4. **Project# 1008042**
11DRB-70308 EPC APPROVED SDP
FOR BUILD PERMIT

INTER-OFFICE MEMO

DATE: October 10, 2011
TO: Jack Cloud, DRB Chair
FROM: Catalina Lehner, Senior Planner *cl*
RE: Project #1003532, La Cueva Area Auto Care
Site Development Plan for Subdivision
Site Development Plan for Building Permit

ENGINEER'S SEAL	FIRESTONE PASEO DEL NORTE & WYOMING BLVD	DRAWN BY JH
	SITE PLAN FOR SUBDIVISION	DATE 11-03-11
	TERRA WEST, LLC 5571 MIDWAY PARK PLACE NE ALBUQUERQUE, NM 87109 (505)858-3100 tierrawestllc.com	2995-SPSB
RONALD R. BOHANNAN P.E. #7868		SHEET # C1
		JOB # 29095

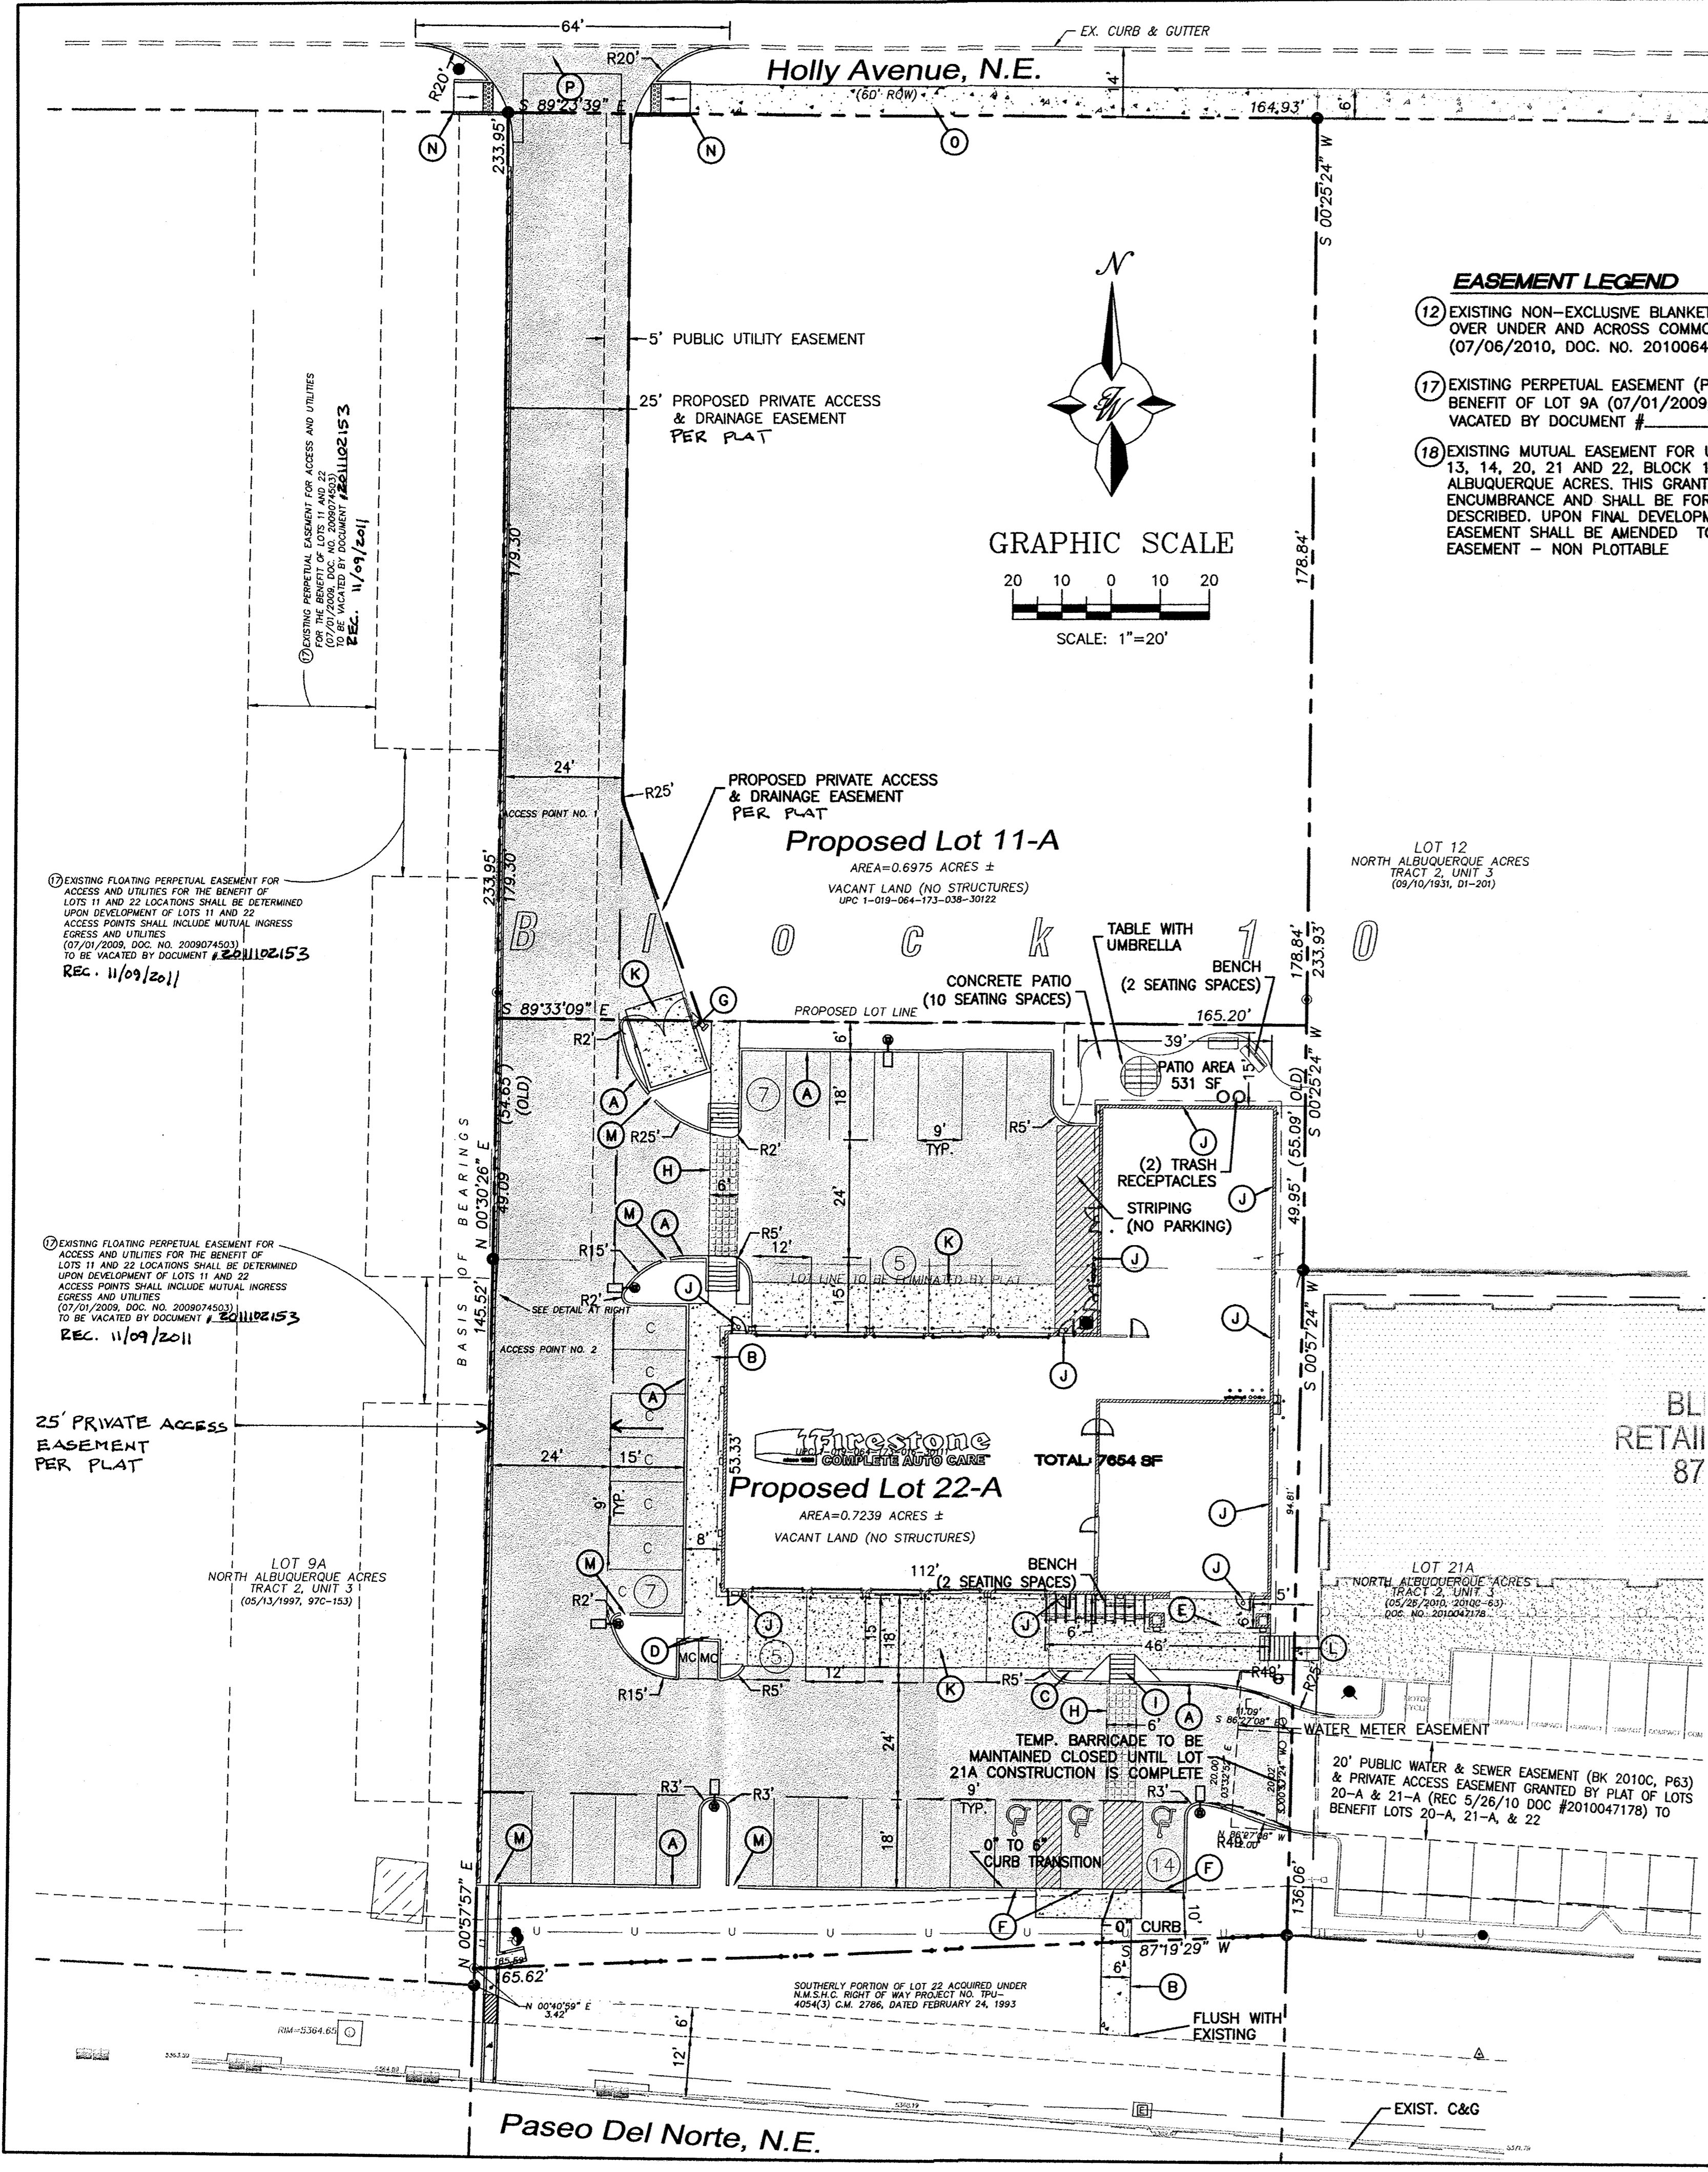
Condition #4A: Note- the fadeback regarding easements and the easement legend is very light- hard to read and probably won't copy.

Condition #6C: Though the area is shown consistently for Lot 22-A, there is a discrepancy for Lot 11-A. On the site, the area is noted as "0.6986 acres" and on the written site date, the area is noted as "0.67 acres". These should be the same number.

Condition #7: This note needs to be added.

ENGINEER'S SEAL	FIRESTONE PASEO DEL NORTE & WYOMING BLVD	DRAWN BY JH
	SITE DEVELOPMENT PLAN FOR BLDG PERMIT	DATE 11-03-11
RONALD R. BOHANNAN P.E. #7868	TERRA WEST, LLC 5571 MIDWAY PARK PLACE NE ALBUQUERQUE, NM 87109 (505)858-3100 terrawestllc.com	2995-SPB
		SHEET # C2
		JOB # 29095

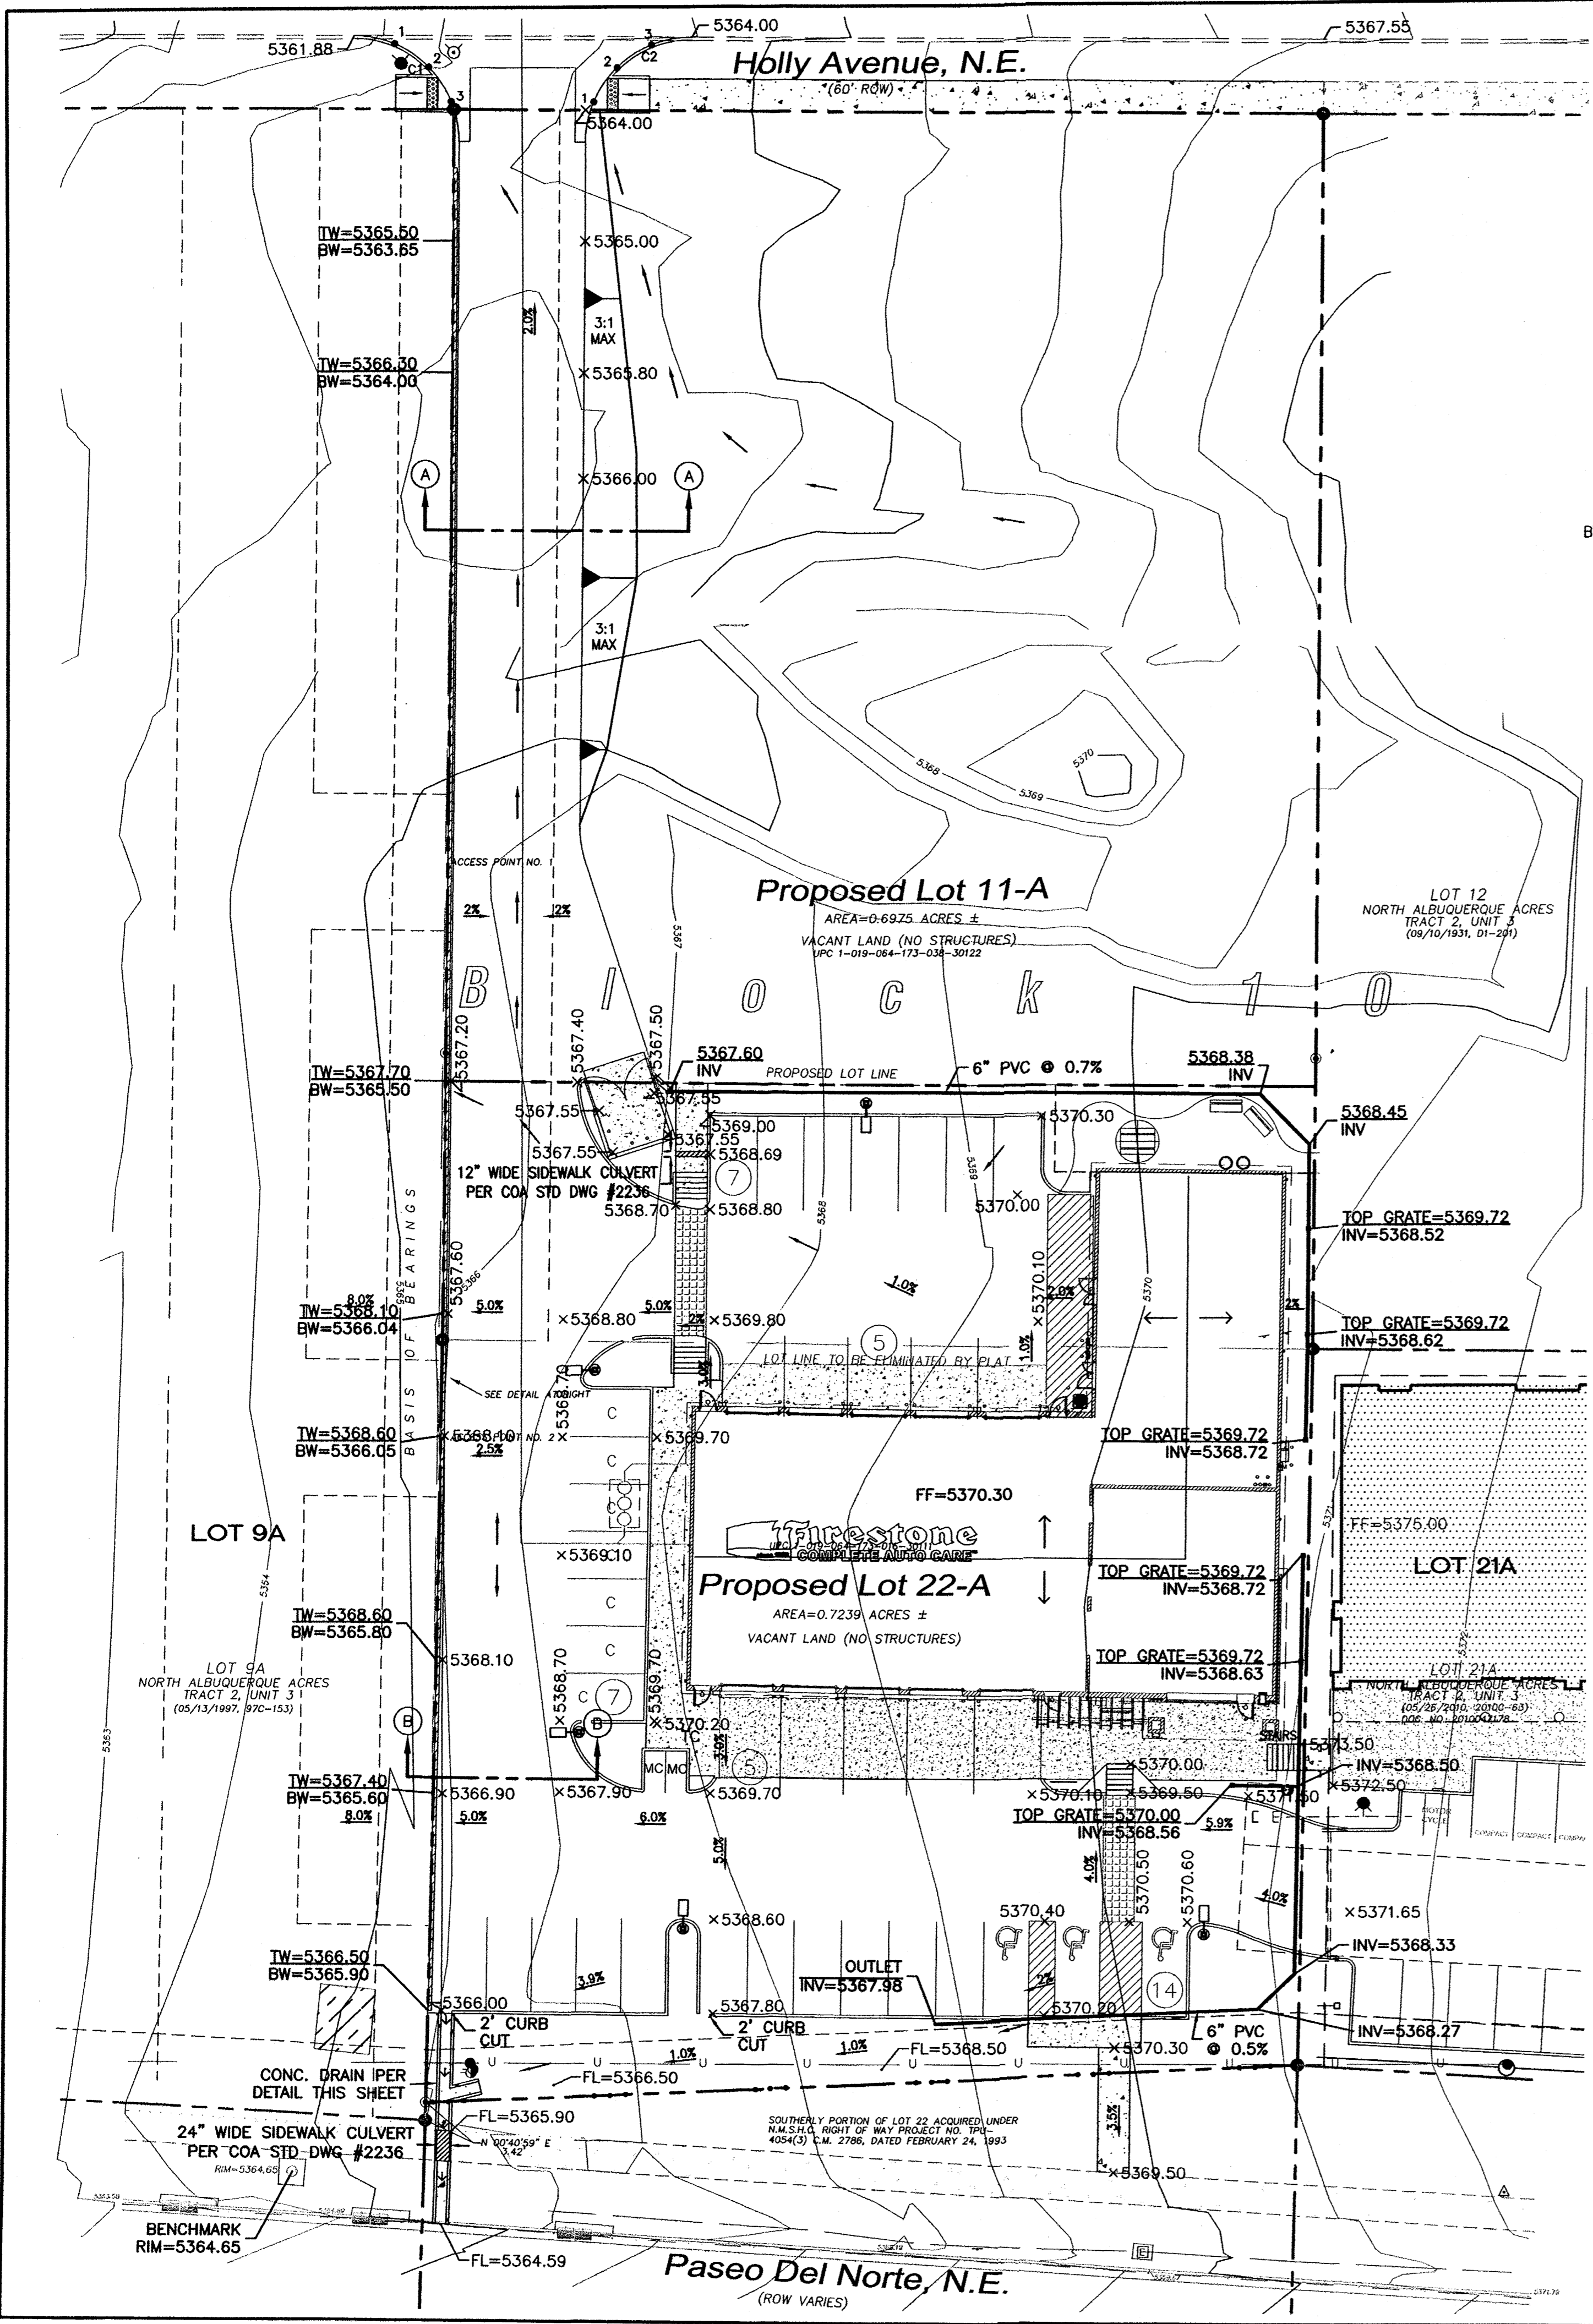
Condition #4B: Dimension the patio area at the building's front entrance (8R-3).

Condition #6A: Dimension the pedestrian pathway on sheet C-2 and on the detail sheet. (for #6A and #6B- the detail says "raised crosswalk" and should also be labeled as "pedestrian pathway" so there is clarity).

Condition #6G: Shading is not provided along the entry façade, except for the garage doors. See explanation under Condition #10B, below.

Condition #8G: The middle curb notch, near the western side of the building, needs to be drawn on the curb.

Condition #10B: (see email from Carmen, dated 8-23-11). The email says that there was an agreement to do a combined trellis/canopy. However, the combined trellis/canopy is not shown on the elevations- only the trellis is, so the agreement was not adhered to. Elevations need to be revised to reflect the agreement. Also, sheet C-2 needs to be labeled to indicate that the space near the main entrance is a trellis/canopy.

Condition #12A: The "caution" note at the bottom of the sheet was not revised to indicate that changes must be approved by the City.
